RE: 1st SDP review comments for # PDD2018 - Liberty Tree Academy

Subject: Liberty Tree Academy
8579 Eastonville Rd.
Peyton, CO 80831
ASEI Project #200300

Re: Review Comments

PROJECT NO.	P20-8579
DATE	APRIL 1, 2020
SCALE	1" = 40'-0"
DRAWN BY	MF
REVISION TITLE	ARCHITECTURAL SITE PLAN
DRAWING NUMBER	SP 1.0

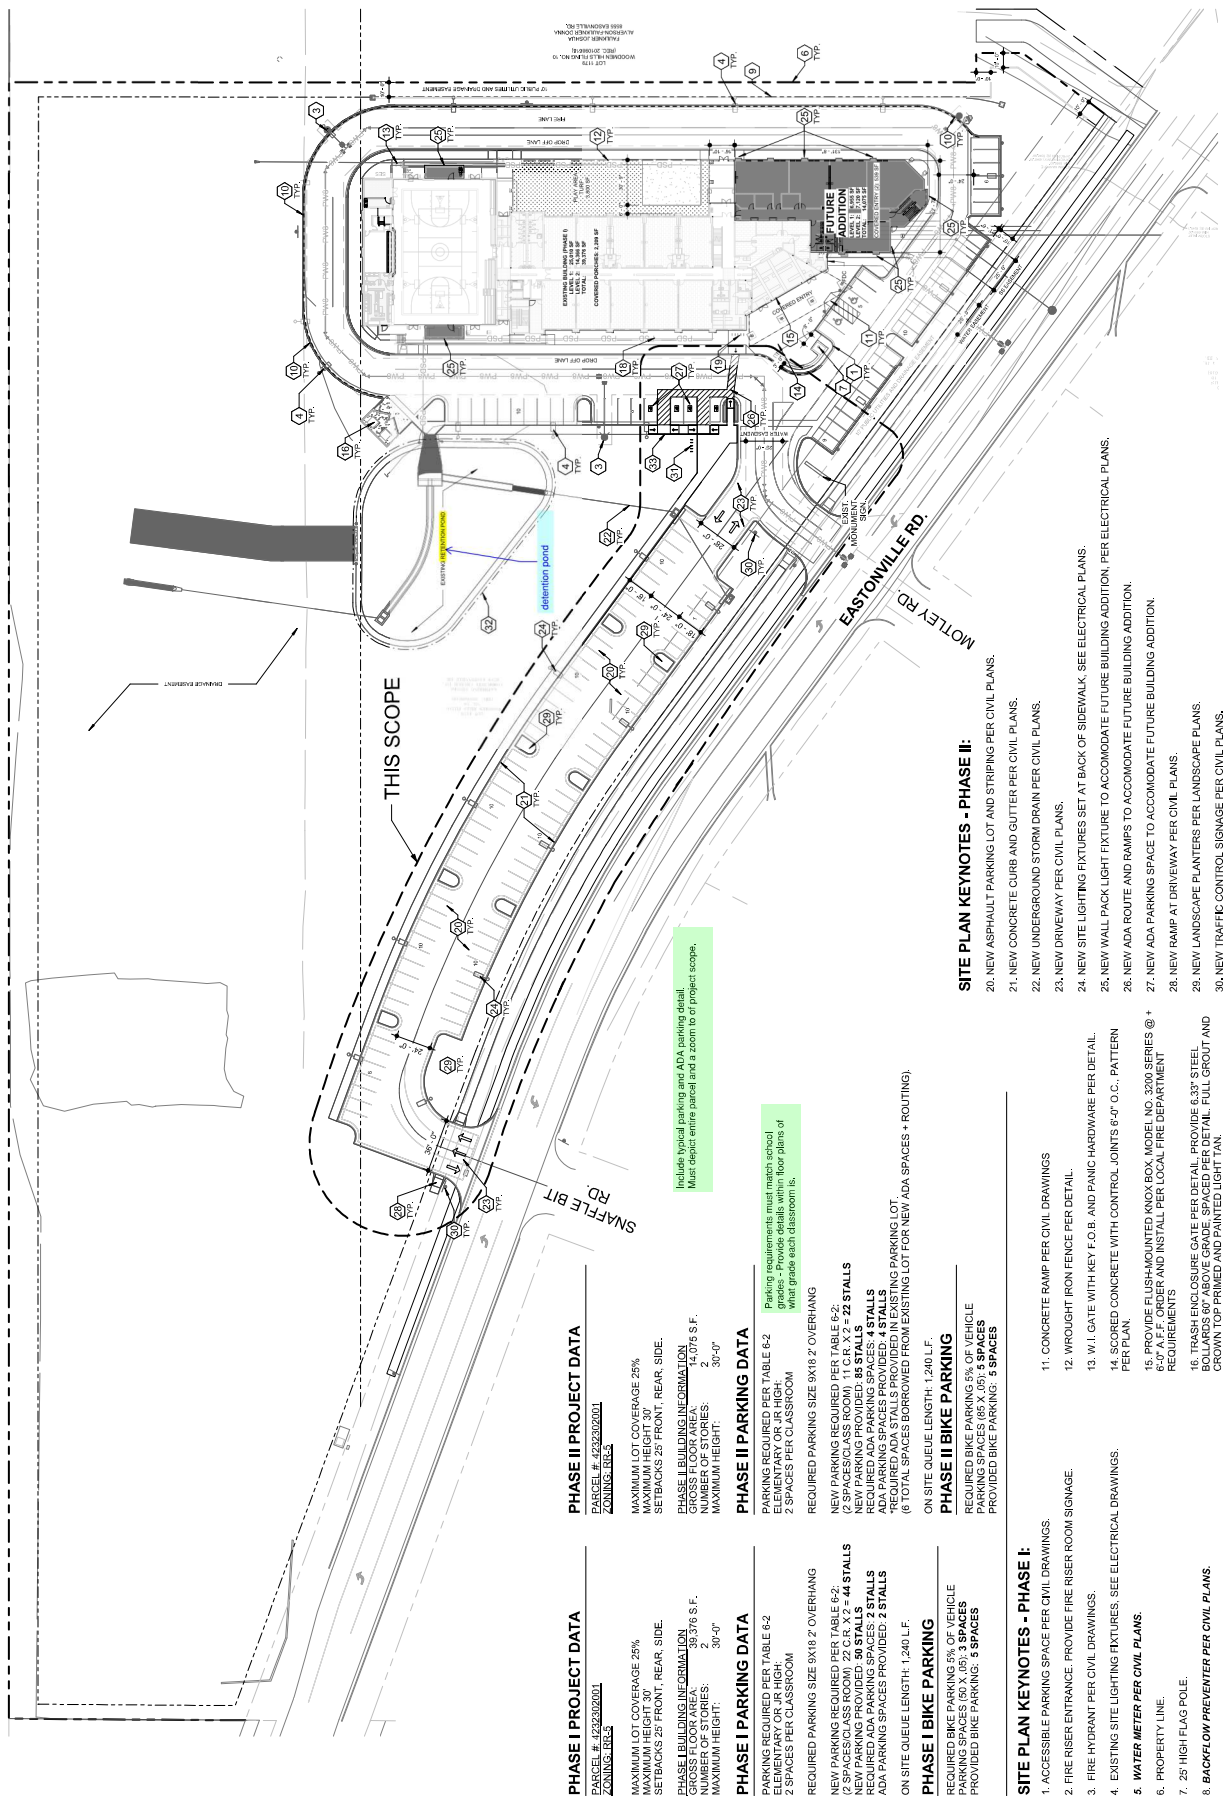
7. Include typical parking and ADA parking detail. Must depict entire parcel and a zoom to of project scope.

8. Parking requirements must match school grades – Provide details within floor plans of what grade each classroom is.

9. Detention Pond.

Details provided – See sheet SP1.1.

See sheets A2.0 & A2.2 for added grades. Please also see added note on sheet SP1.0.

Updated – see sheet SP1.0

NEW PARKING LOT FOR:	
LIBERTY TREE ACADEMY	
8579 EASTONVILLE RD. PETYON, CO 80851	
CONSTRUCTION DOCUMENTS	
PROJECT NO.	P20-8579
DATE	APRIL 1, 2020
SCALE	As Indicated
DRAWN BY	MF
CHECKED BY	
DATE	
PROPOSED FLOOR PLAN LEVEL	
DRAWING NUMBER	A2.0

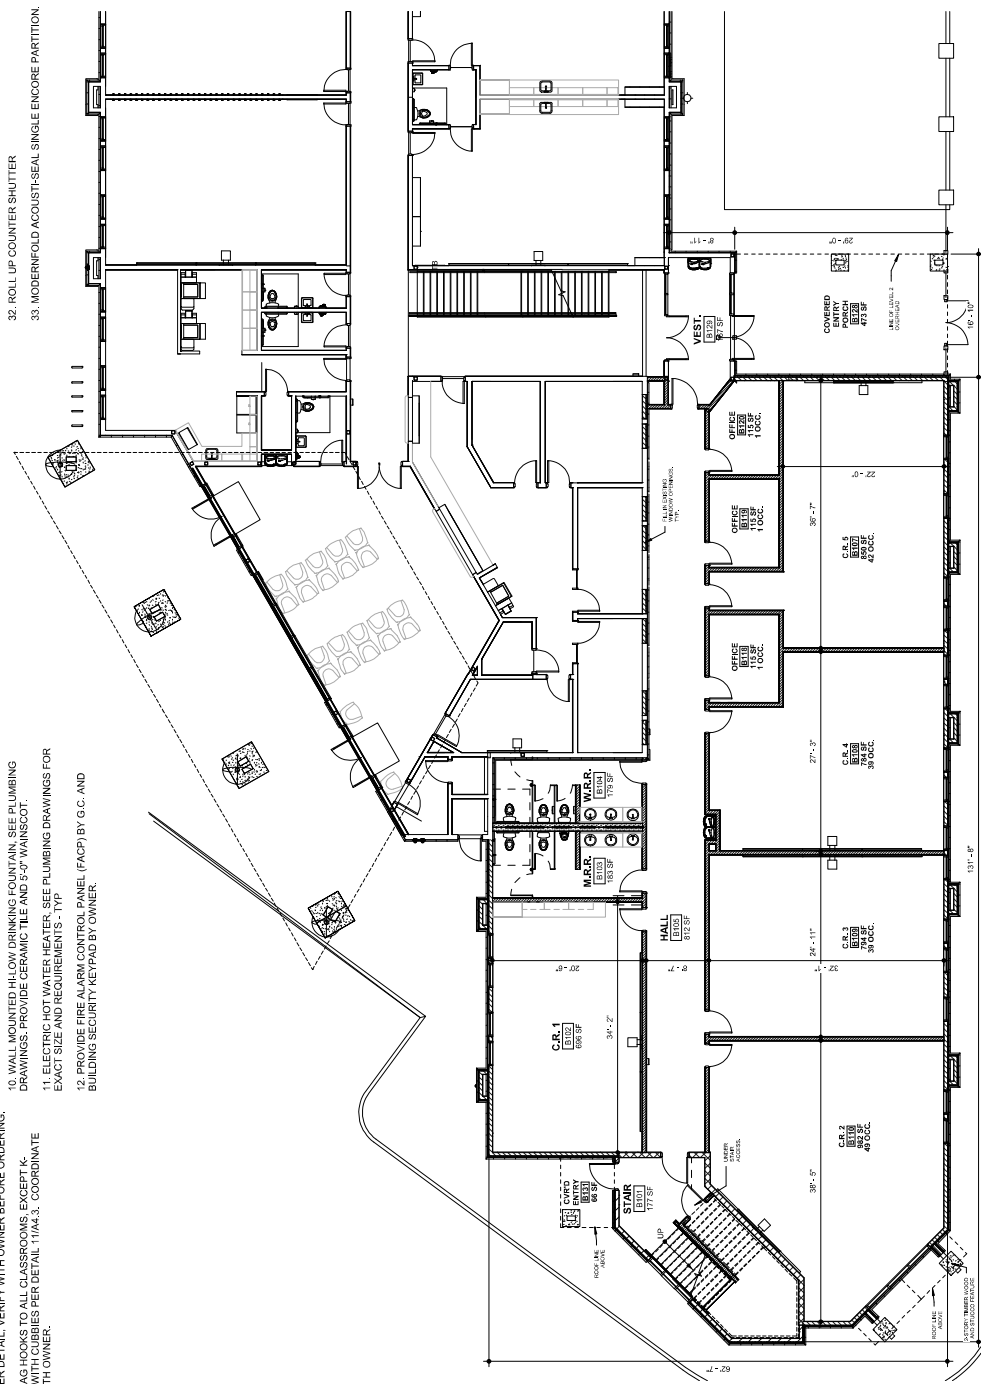
10. Provide grade level details of classrooms.

Updated – See sheets A2.0 & A2.2.

DATE: APRIL 1, 2020
SCALE: As Indicated
DRAWN BY: Author
PHOTOMETRIC PLAN
DRAWING NUMBER: E1.2

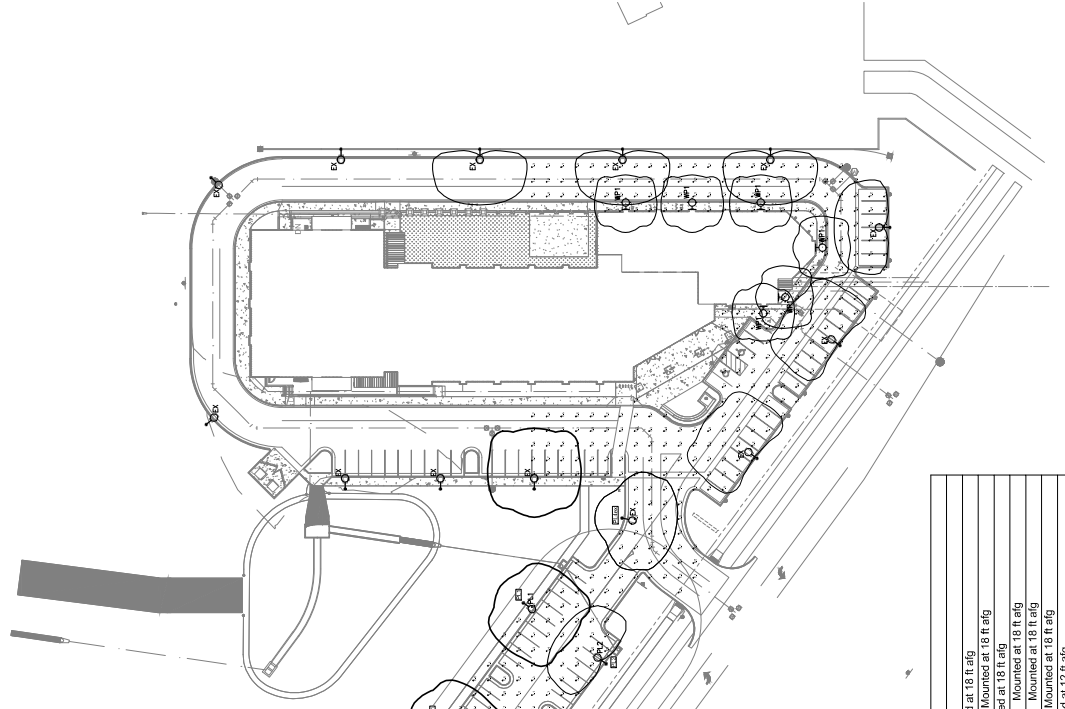
- 1) Comment: Incomplete lighting pan. Must show light levels at property lines. Provide elevation drawings of lights.

12. Incomplete lighting plan. Must show light levels at property lines. Provide elevation drawings of lights.

Response: Corrections made. Please see E1.2. Photometric extended to property line. Pole detail elevation provided on sheet. Calculation added to show spill at property line.

See revised sheet E1.2 for additional Calculation Summary & Luminaire Schedule.

Also, see sheet E1.2 for Fixture elevation detail.
